PLANNING CONSULTATION RESPONSE

Application No	2026/0014
Proposal	Proposed steel containers to be converted into a private bar with car sales offices above. (Retrospective)
Address	Unit 2, Park Springs Spring Hill Road, Grimethorpe, Barnsley, S72 7BQ
Date of Consultation Reply	10/06/2026
Consultee	Katie Lawrence, Planning Ecologist

2 SITE PLAN
1 : 500

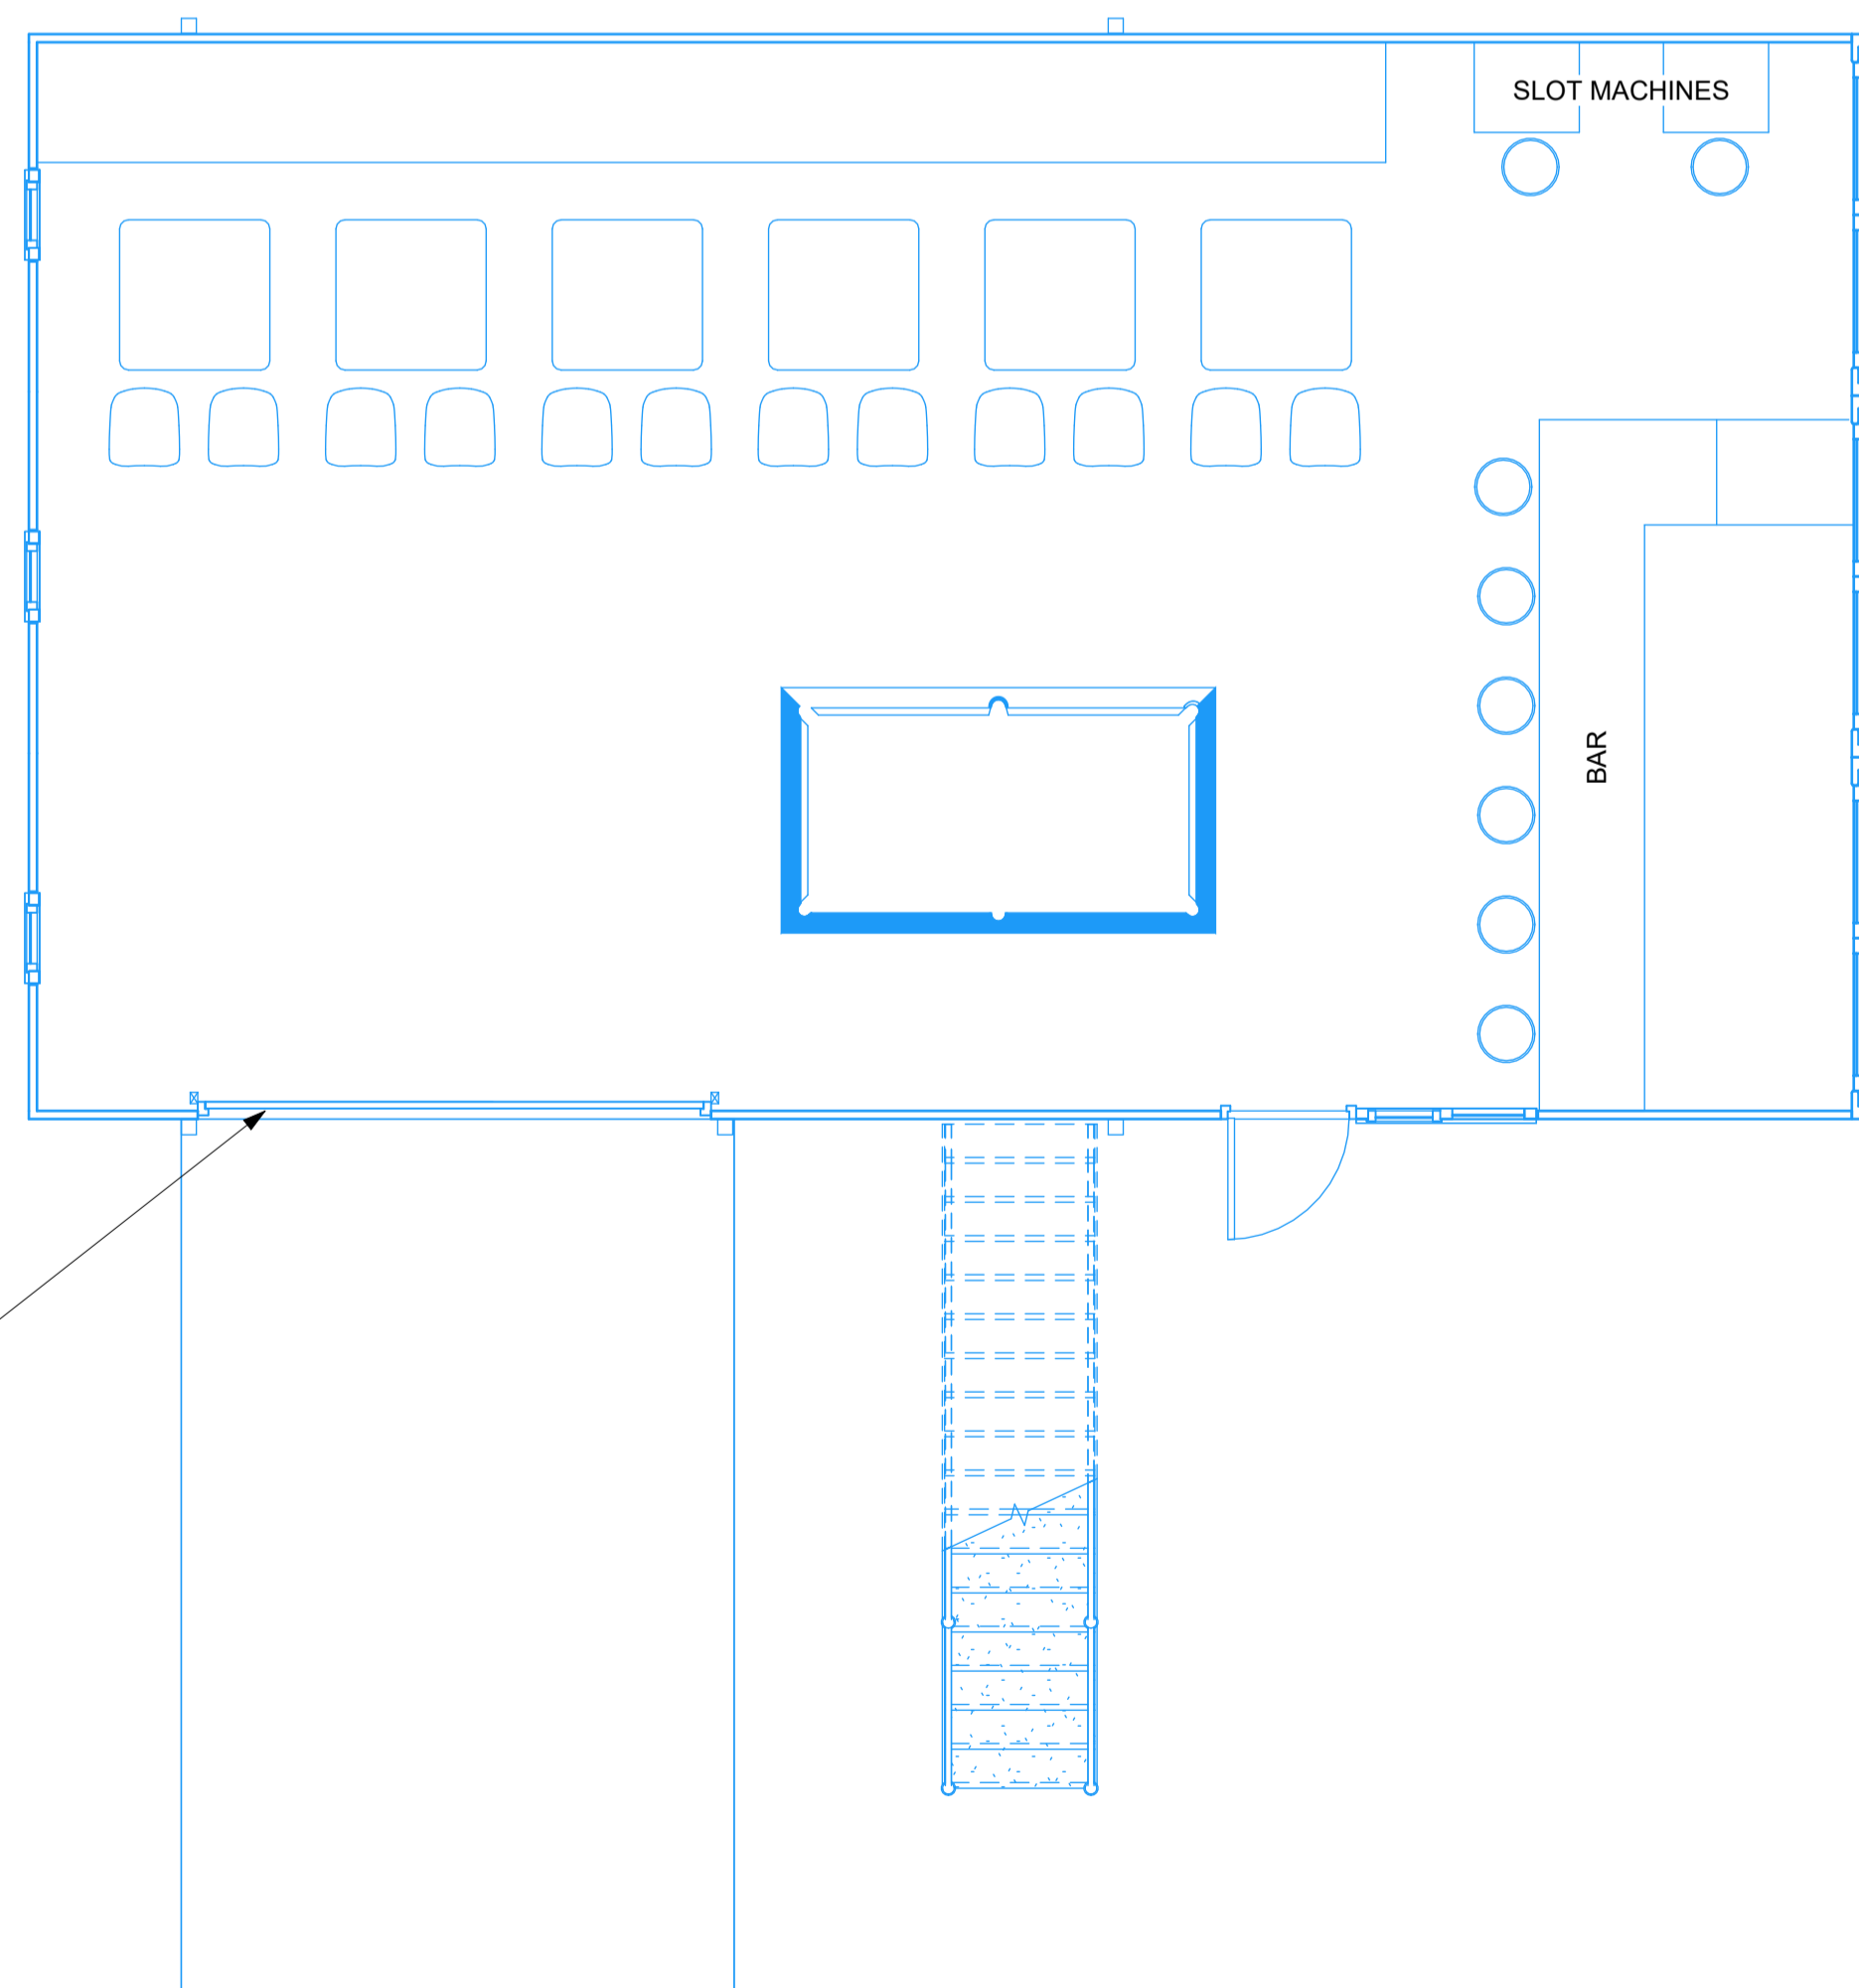
- A biodiversity metric has been submitted with the application; however, as it is a retrospective application, Biodiversity Net Gain does not apply. Regardless of this, landscaping should be incorporated on site in the aim to mitigate loss of an area of native scrub habitat.

- As detailed above, the applicant should submit plans indicating proposed planting on site to mitigate for the loss of the scrub habitat. Reference should be made to the survey results of the PEA to inform an appropriate landscape strategy.

- Recommendations within the PEA include the incorporation of tree mounted boxes for birds and bats, which is welcomed. The applicant should provide plans indicating the potential locations of such boxes, or incorporation onto buildings if trees are not suitable.
